211541 CAAL

173-179 Walker Street, North Sydney

Proposed Changes to Early Works Stormwater Diversion (SSD-67175465)

Figure 6 Proposed location of the stormwater pits

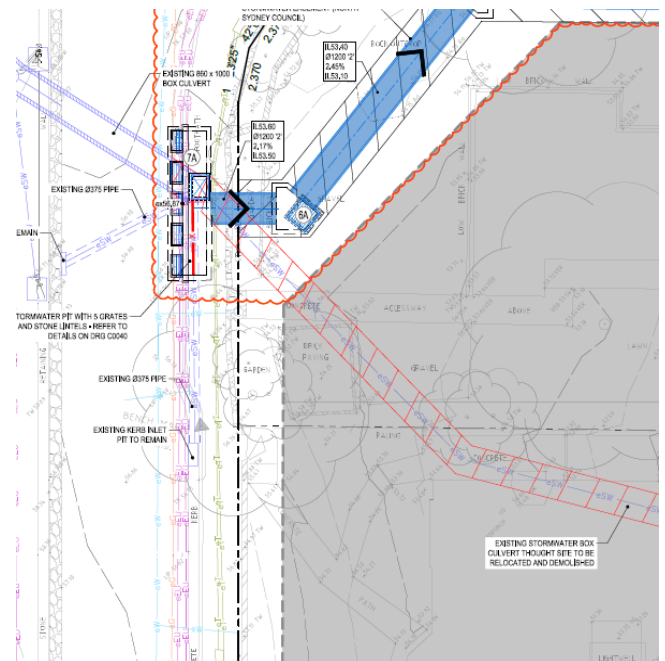
1. Relocation of Proposed 5-Grate/Lintel Pit with Stone Inlet (Pit 7A)

Site investigations have confirmed that the existing 860mm × 1000mm box culvert traverses the site in a perpendicular alignment to the retaining wall, rather than the diagonal alignment shown on the original survey. To reflect the confirmed culvert alignment, reduce on-site construction complexity, and utilise existing pits to achieve a direct connection, it is proposed to relocate Pit 7A directly over the existing box culvert.

This revision removes unnecessary pipework and transitions and allows the pit to function as intended, without introducing any additional structural or hydraulic risk. The relocation of this pit and retention of the existing sag inlet pit to the south matches the intake capacity of the previously submitted design.

2. Modification of Pit 6A

As a result of the revised location of Pit 7A and the confirmed alignment of the existing pipe through the site, Pit 6A has been adjusted to suit the updated pit and pipe arrangement. This ensures continuity of the stormwater system and appropriate pipe alignments are maintained.

173-179 WALKER STREET, NORTH SYDNEY										SITEWORKS AND STORMWATER MANAGEMENT PLAN, SHEET 1										1:100										LA										CR

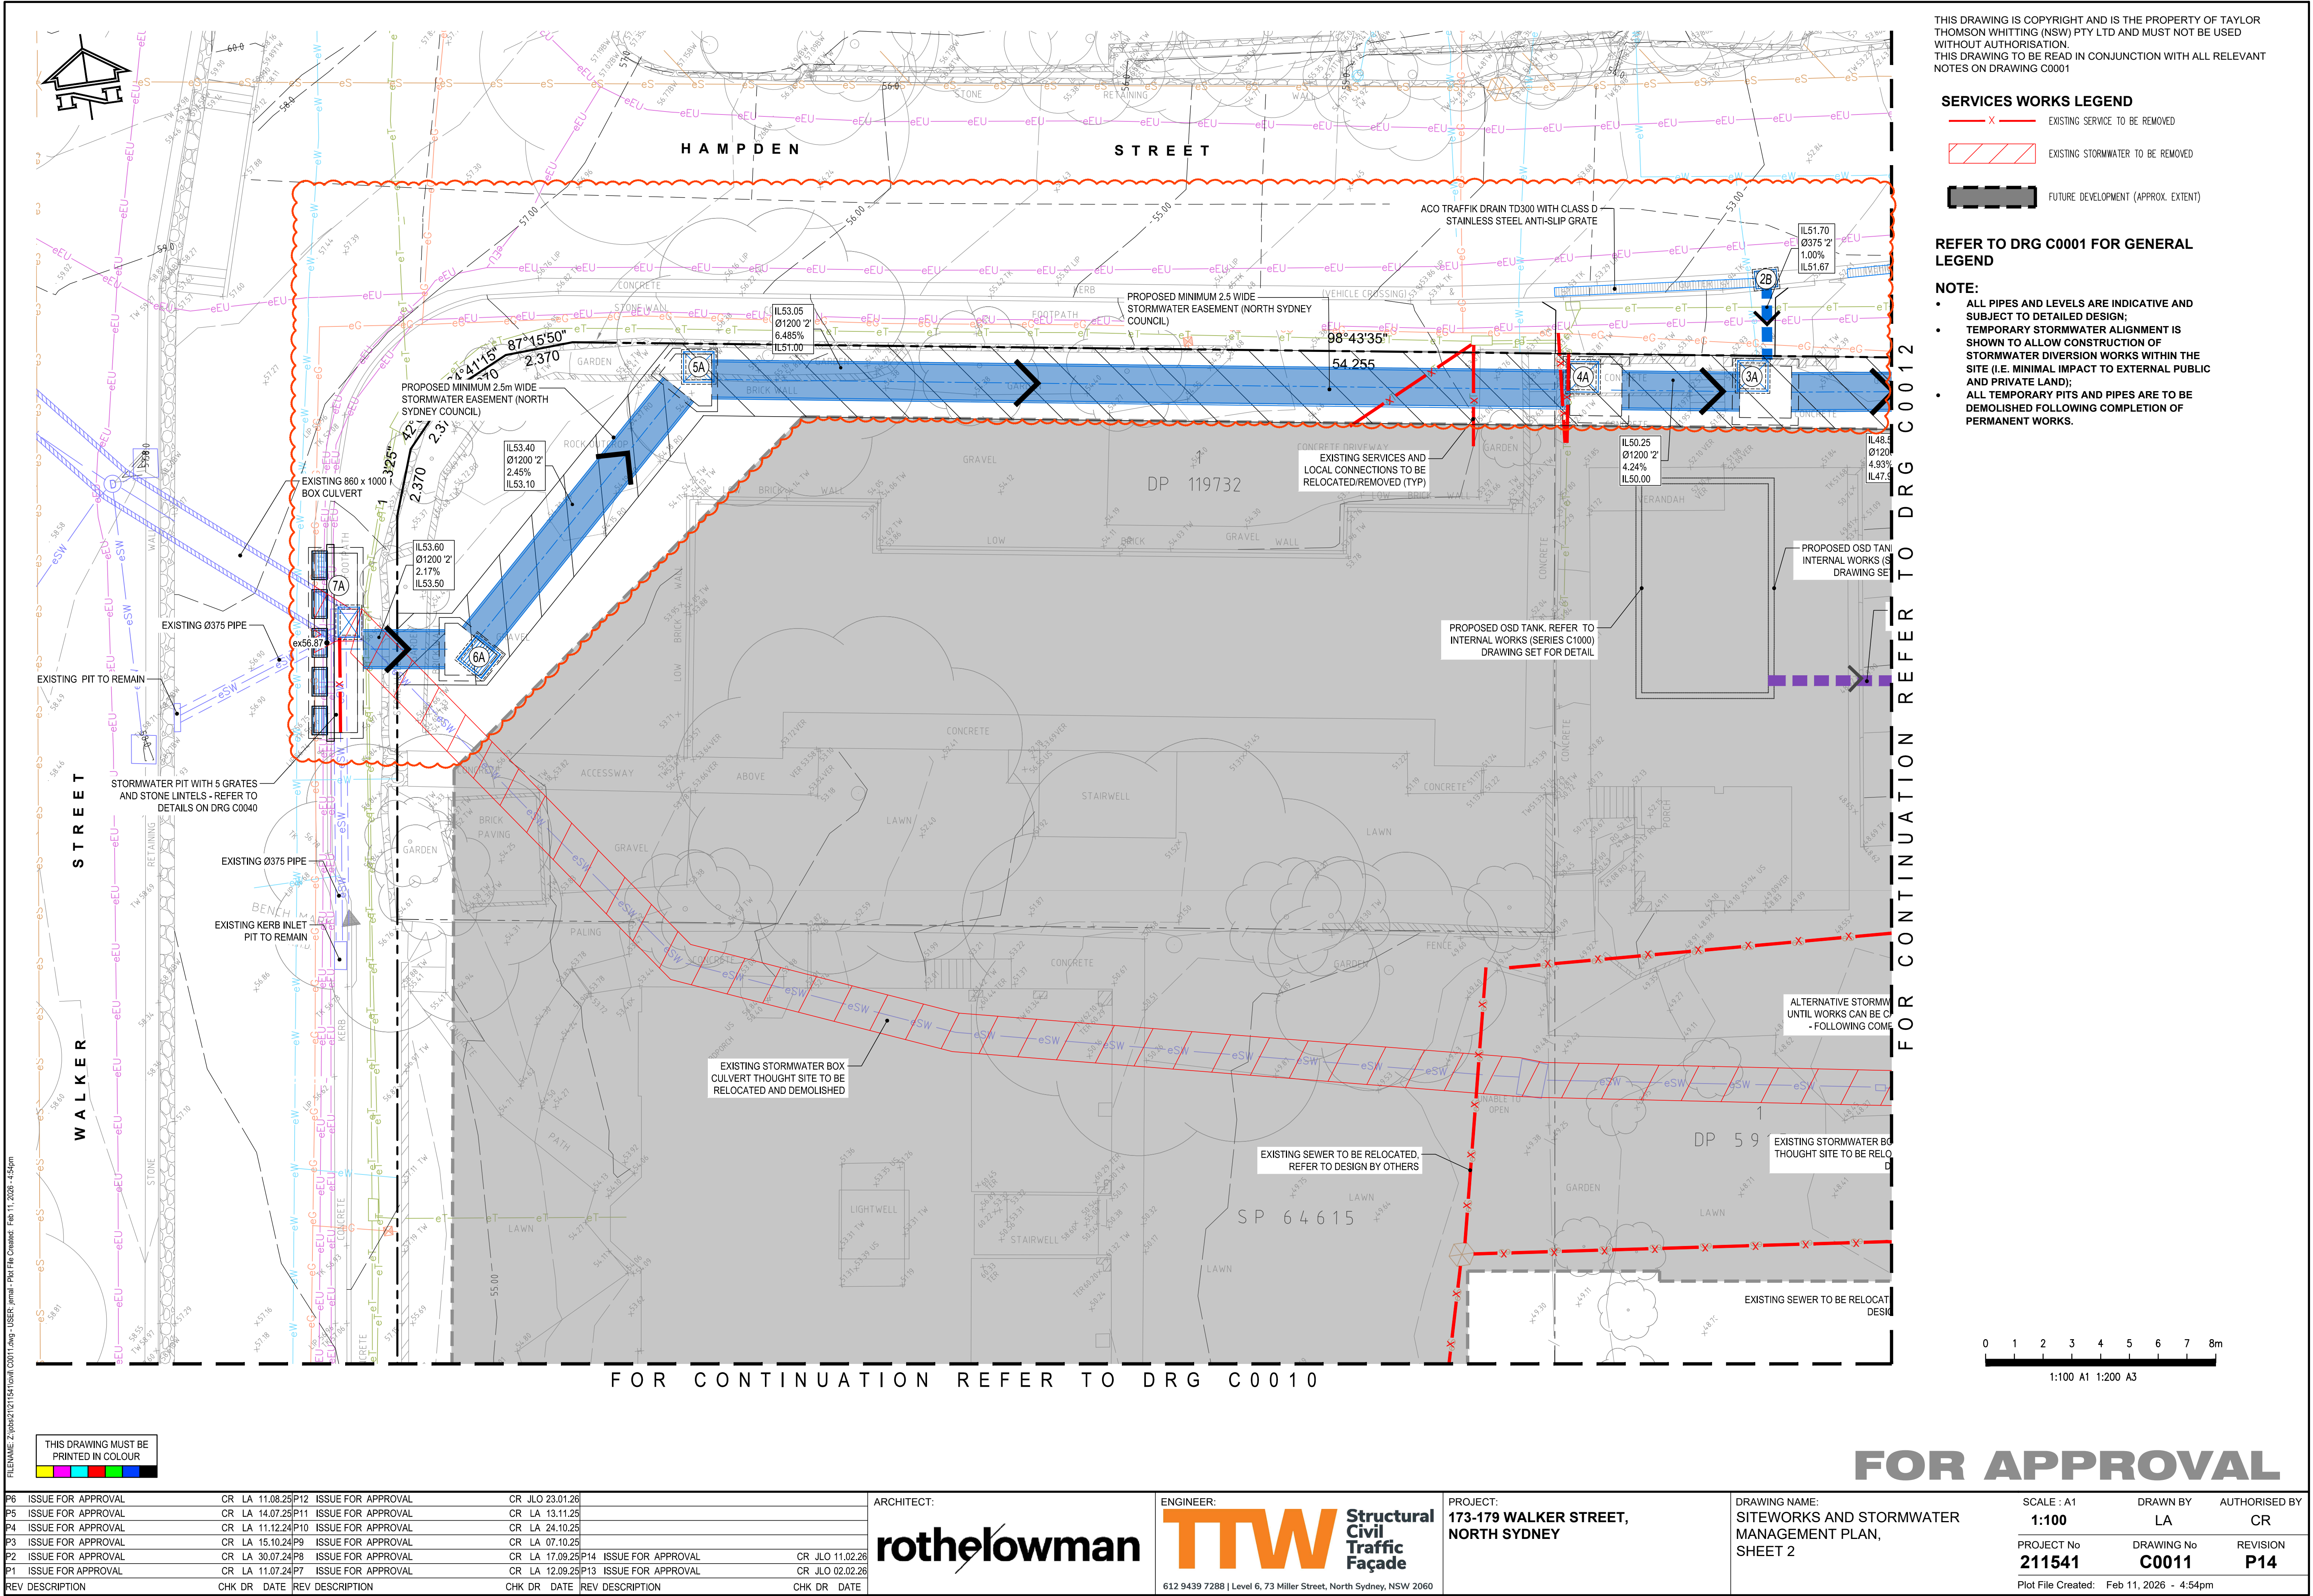
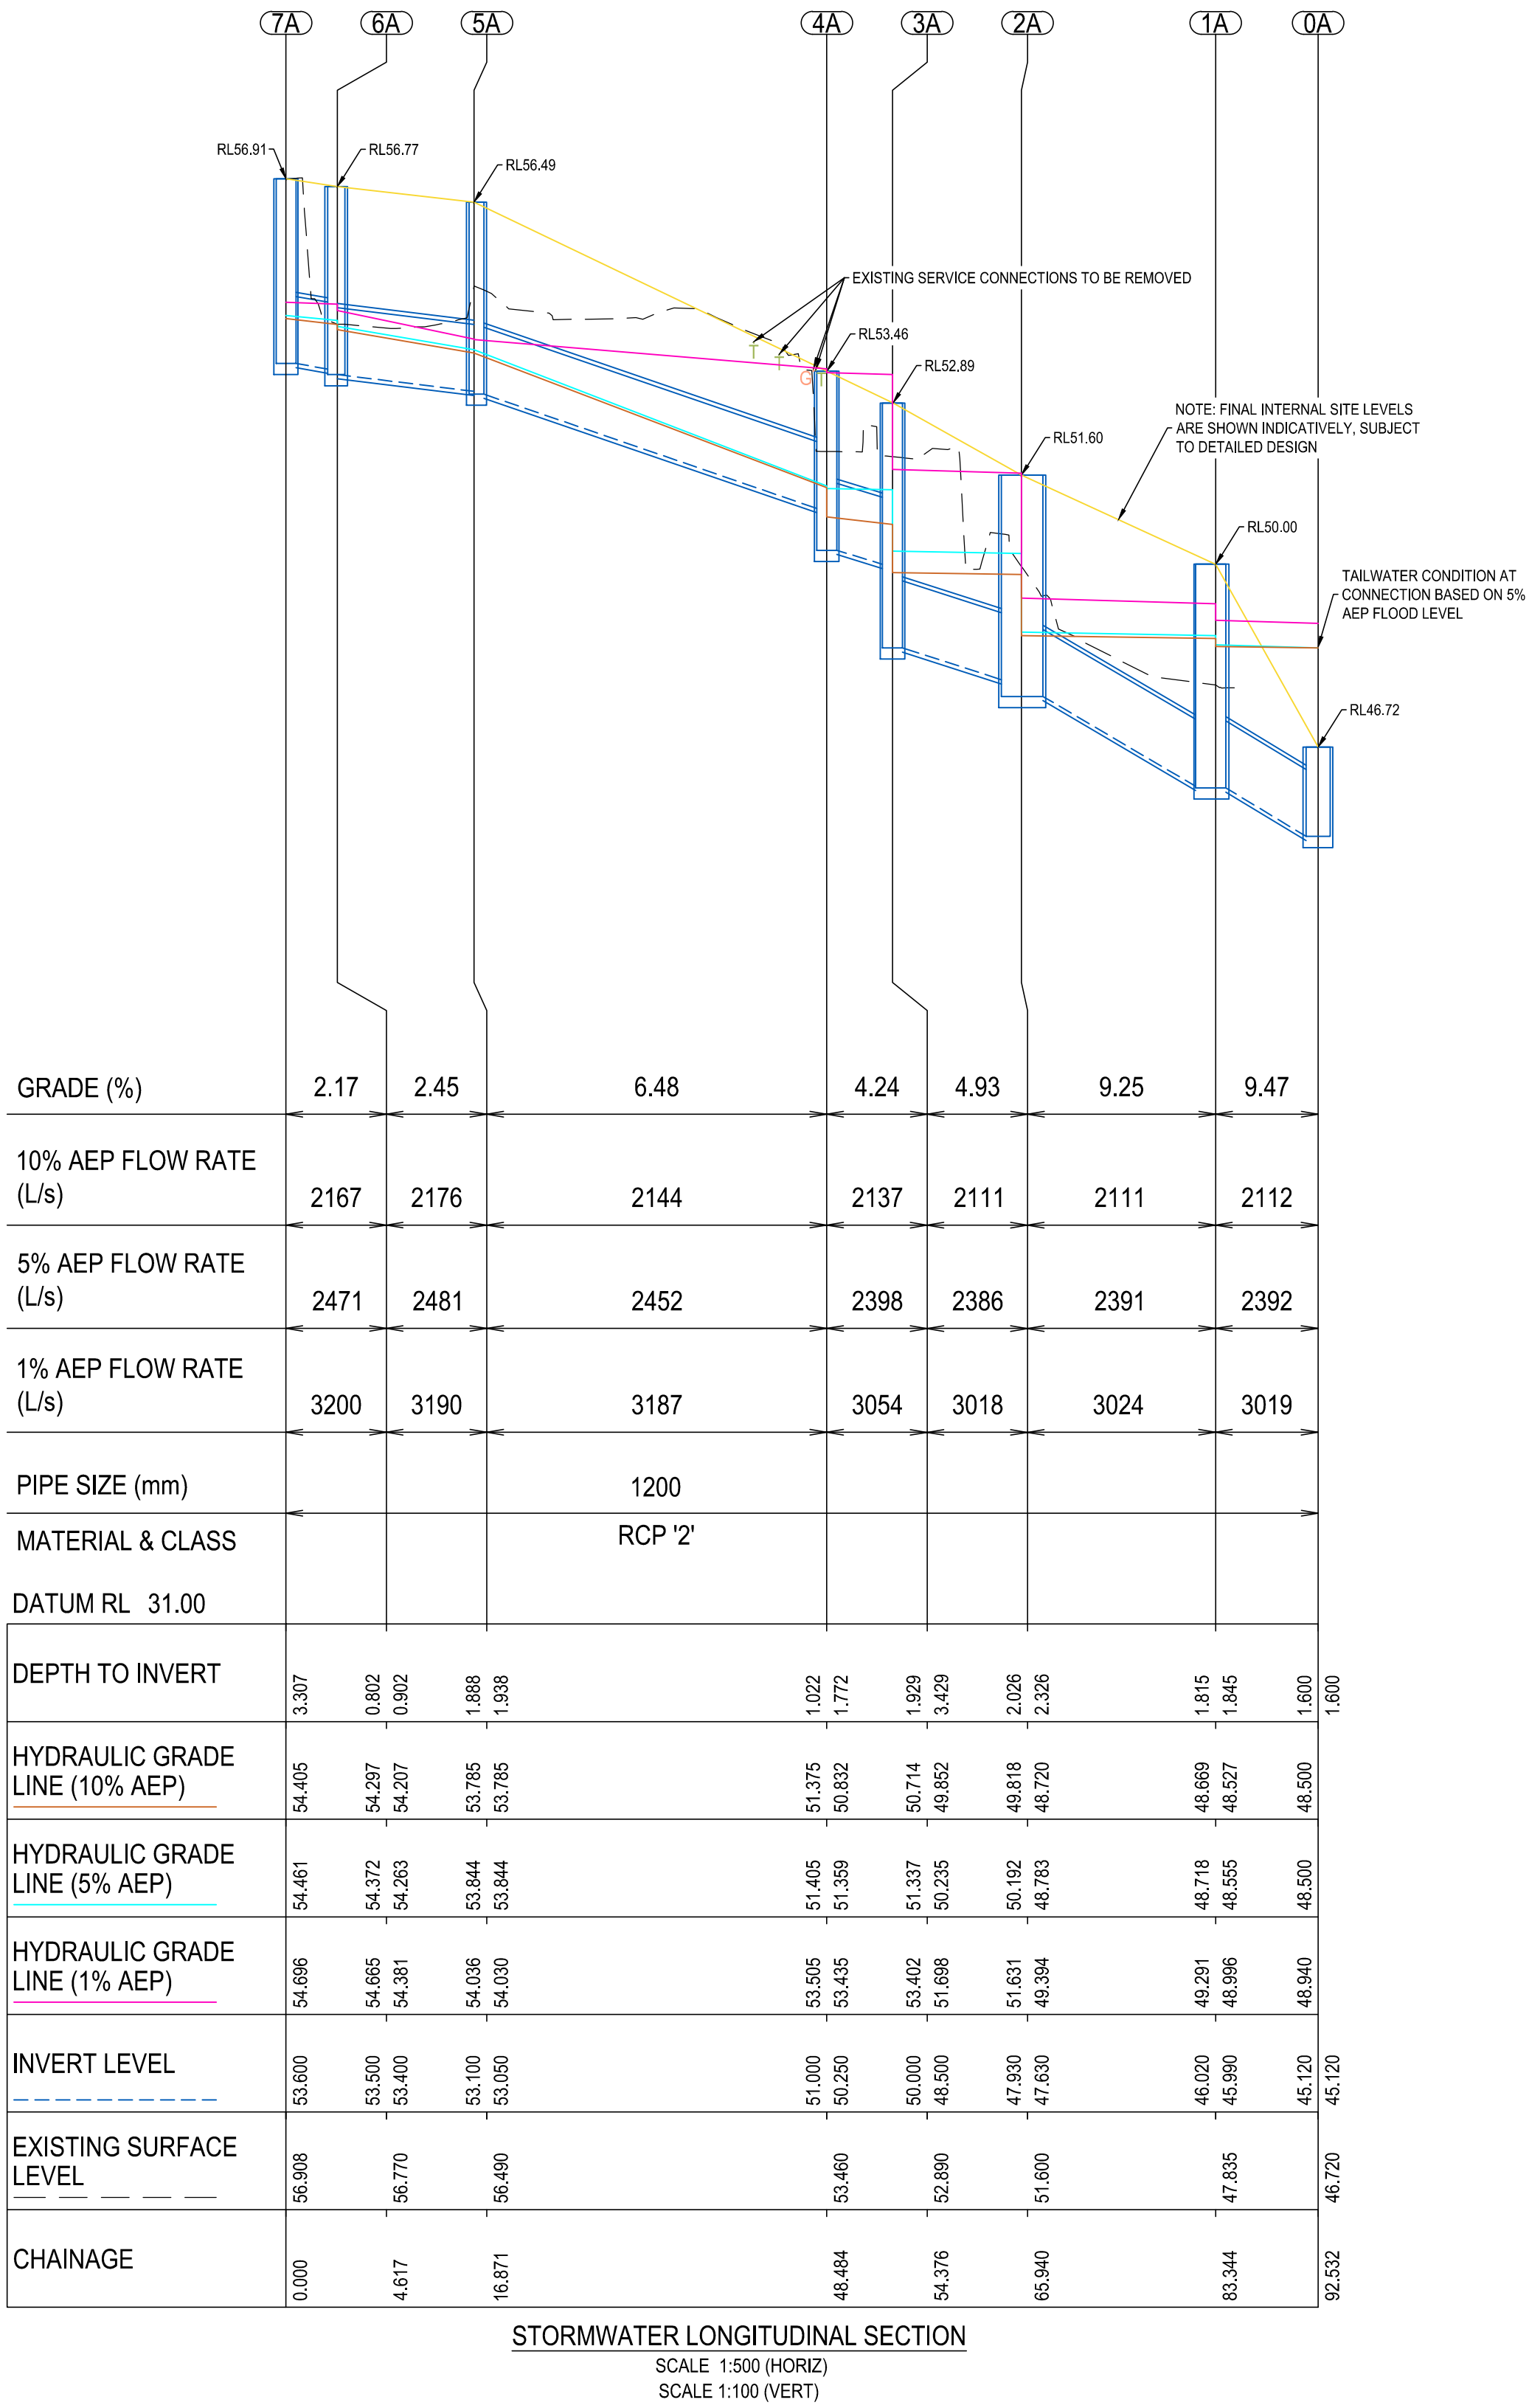
3. Relocation of Stormwater Diversion Within the Site Boundary

The stormwater diversion alignment has been revised to be located within the site boundary parallel to Hampden Street (the previous proposal had the pipe within and along the centre of Hampden Street). This change avoids known clashes with existing infrastructure within the public road reserve and eliminates the need for relocation and coordination with third-party service authorities.

By matching the previous submitted pipe size, there is no loss of hydraulic capacity of the system with this change.

4. Replacement of Kerb Inlet Pits with Grated Drains

It is proposed to replace the previously approved four kerb inlet pits along Hampden Street with two 300mm wide grated drains, each 7.0m in length, providing a total inlet length of 14.0m. Each of the grated drain is proposed to have a 450 x 600mm surface inlet pit at the end, discharging via a proposed 375mm diameter outlet.
